From: Holly Duncan
Sent: Friday, January 15, 2016 9:52 AM
To: Jeff Watson
Cc: Holly Myers
Subject: RE: Notice of Application: SP-15-00007 Riste

NOTICE OF APPLICATION: SP-15-00007 RISTE

DRAWING TYPE: SHORT PLAT APPLICATION

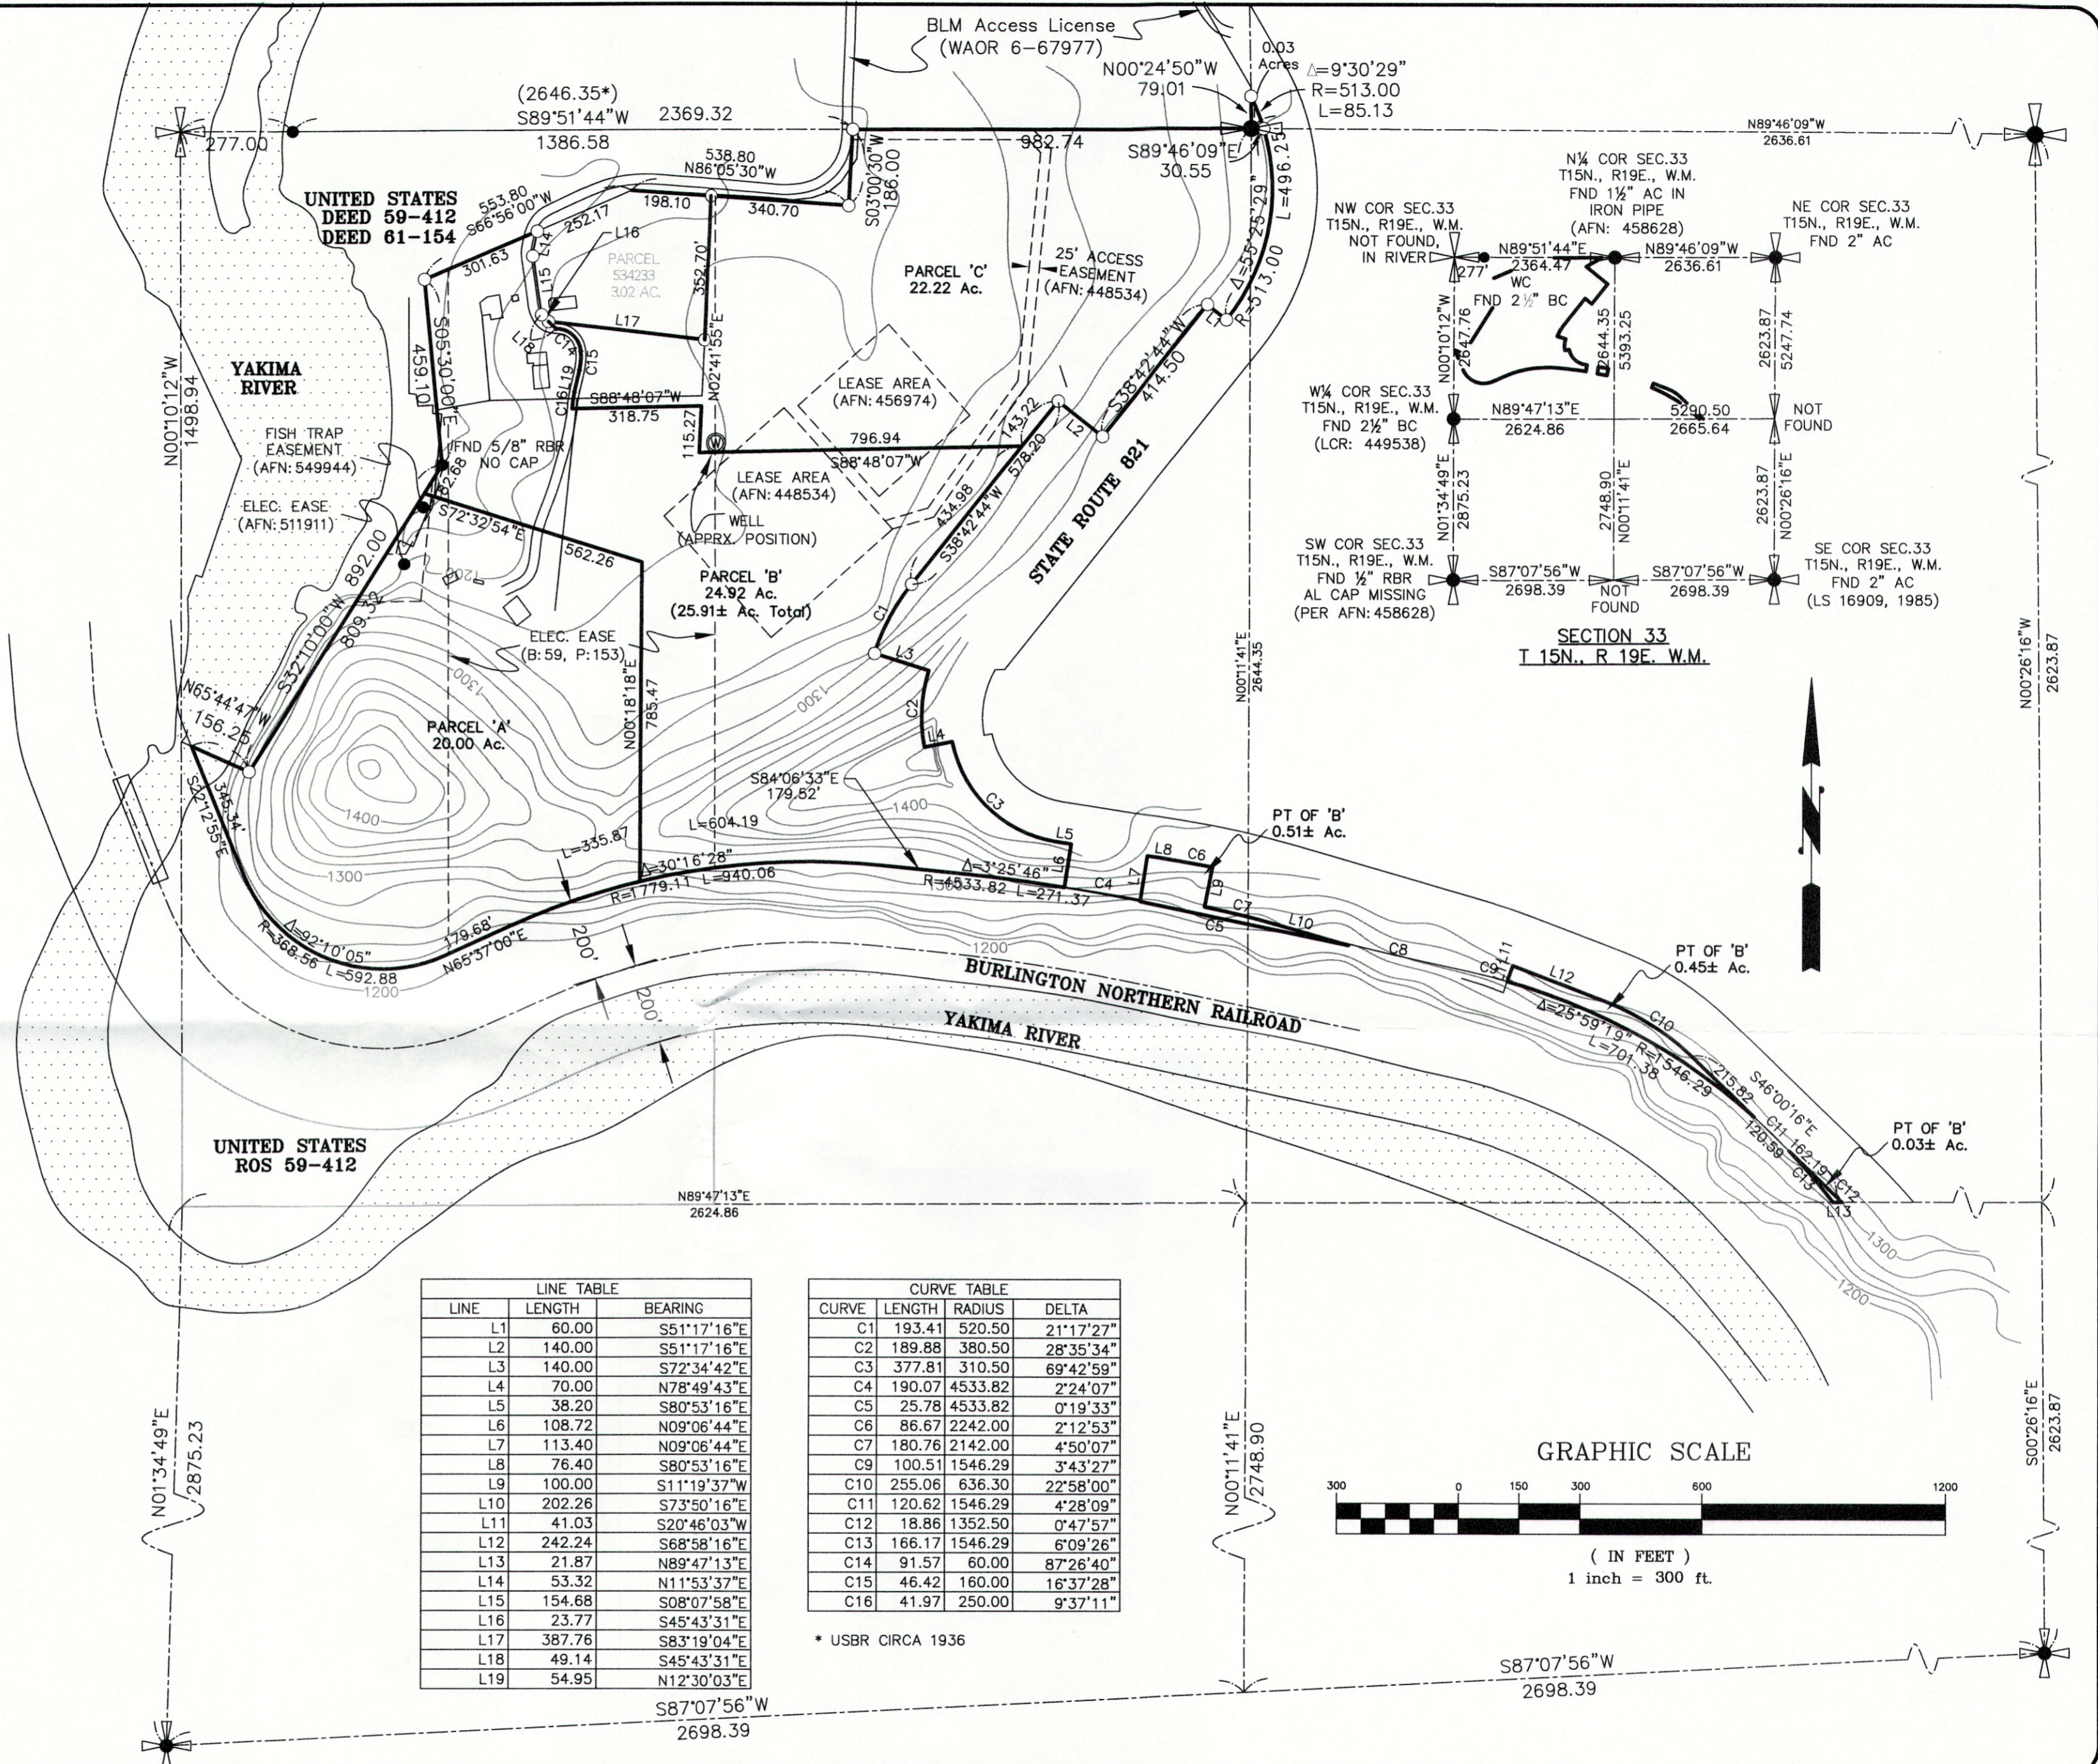
The well that is located on the proposed parcel C may not be the required 50 feet from the property line. Does this mean the well will be proposed as a shared well between parcels B and C if it isn't 50 feet from the shared property line?
